Permit Number: 091294

RE: 261-269 Valley Street (former site of Eagles Club)
Accessory 10 space Parking Lot

On November 10, 2009, the Portland Planning Authority approved a minor site plan for paving and landscaping to create a 10 space parking lot on the site of 261-269 Valley Street (former site of Eagles Club) as an accessory use to the building at 48-52 Gilman Street. The approval is based on the submissions made on behalf of Maine Medical Center and as shown on the approved plans (Sheet 2 Rev B and Sheet 3 Rev B) prepared by Sebago Technics and dated 11/3/2009 with the following conditions:

**VERTICAL GRANITE CURB**  
 NOT TO SCALE

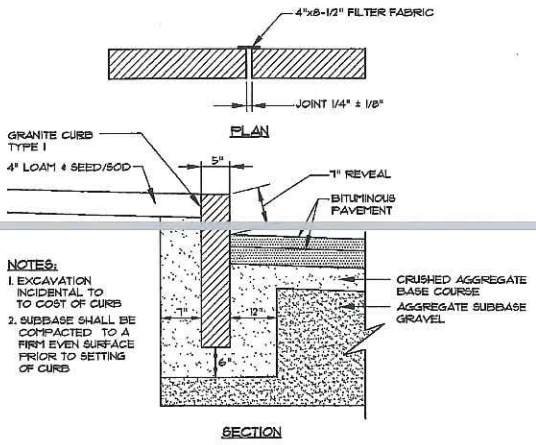
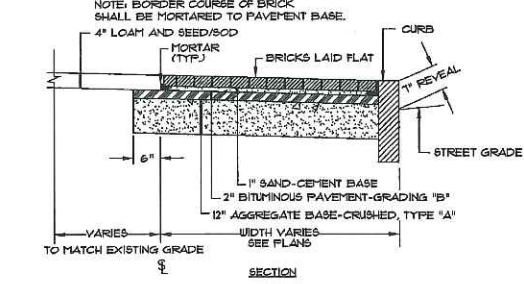
There are no curbing details to show how the cars will stay on the pavement provided.
